Planning Application Ref: A/81/18/RES

Location: Quiet Waters, Roundstone Lane, Angmering

Description of works: Approval of reserved matters following outline consent A/132/17/OUT for appearance, landscaping, layout & scale for demolition of existing dwelling & the erection of 30 No. dwellings. This application is a Departure from the Development Plan.

Tree Officer / Parks and Greenspace Team

Drawing Title:
Proposed Site Layout

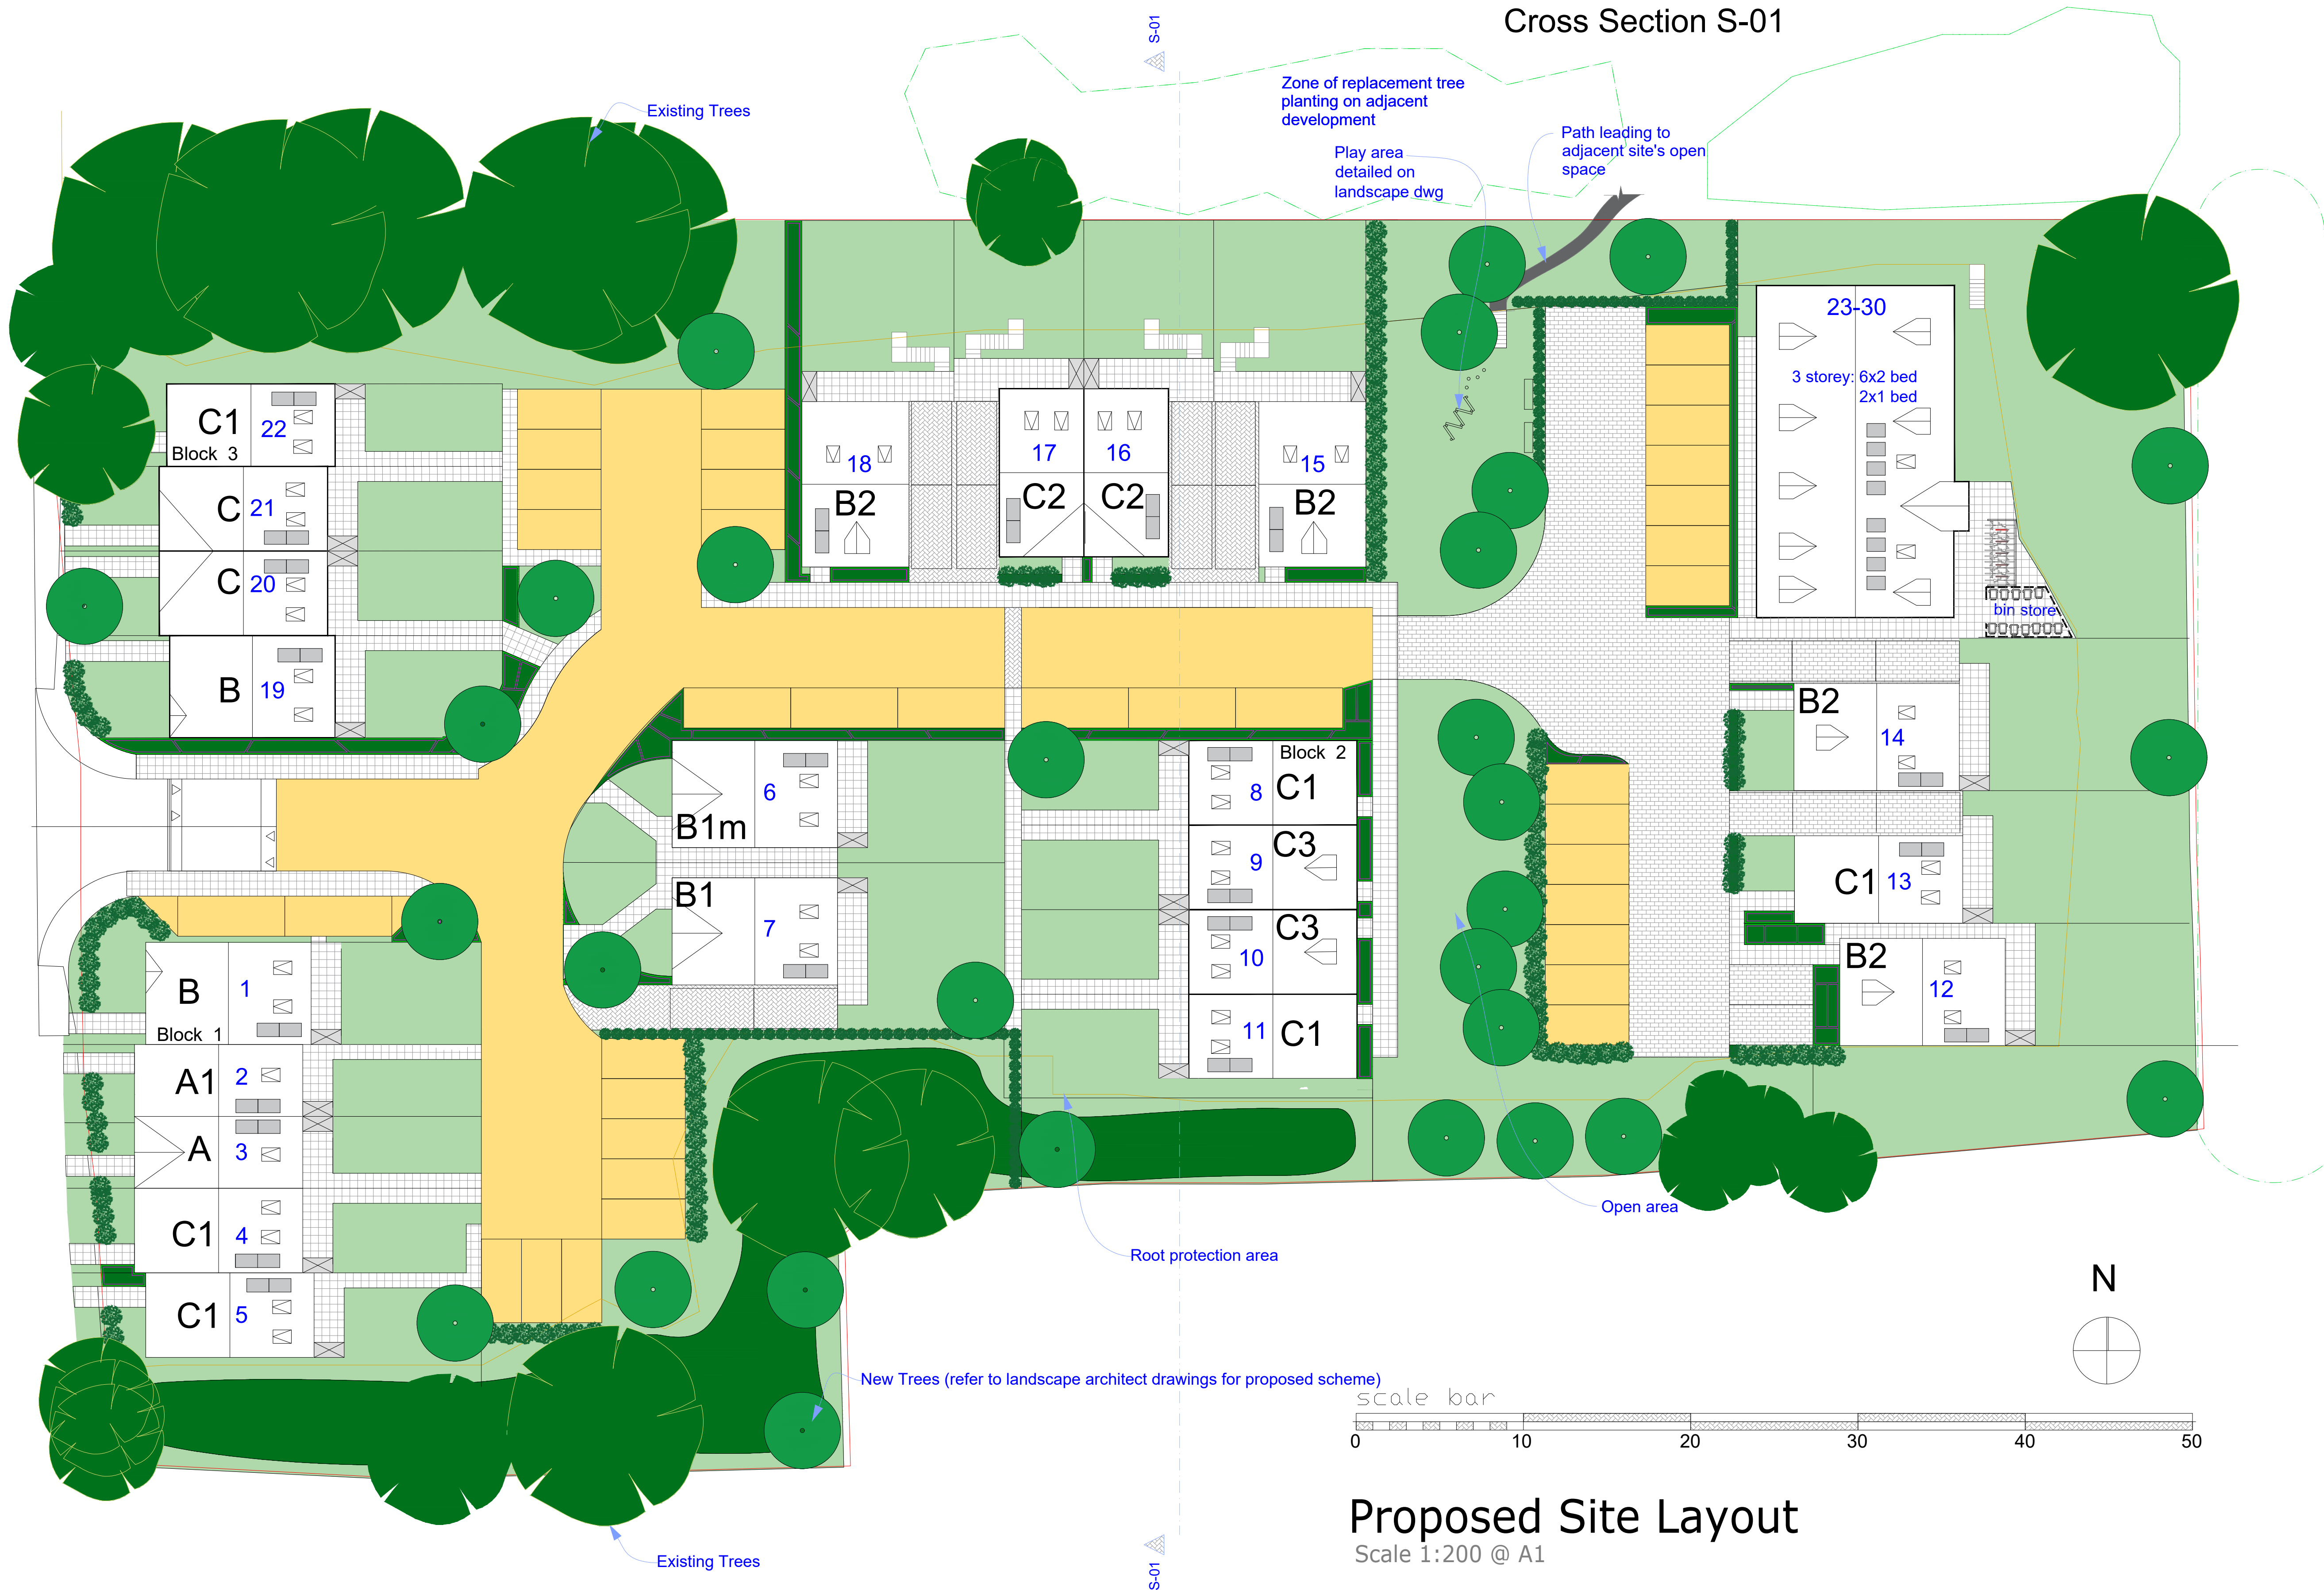
- 1.2. The latest Proposed Site Layout submitted by BEDARO, dwg.no. ANG101 Rev J, May 18 shows a reliance on constructing retaining walls around the site to accommodate the significant embankments. These are shown to be outside of most retained tree RPAs although some intrusion is proposed along the southern boundary. While broadly tolerable in respect of tree retention, it is undesirable and the oppressive feel of trees growing from high embankment so close to residential dwellings will compound the pressure to prune/fell.

- 1.5. The latest site layout is perhaps the best possible design incorporating this number of units. That said, it demands the removal of a high number of existing trees and places many retained trees of value under future pressure to prune or remove.
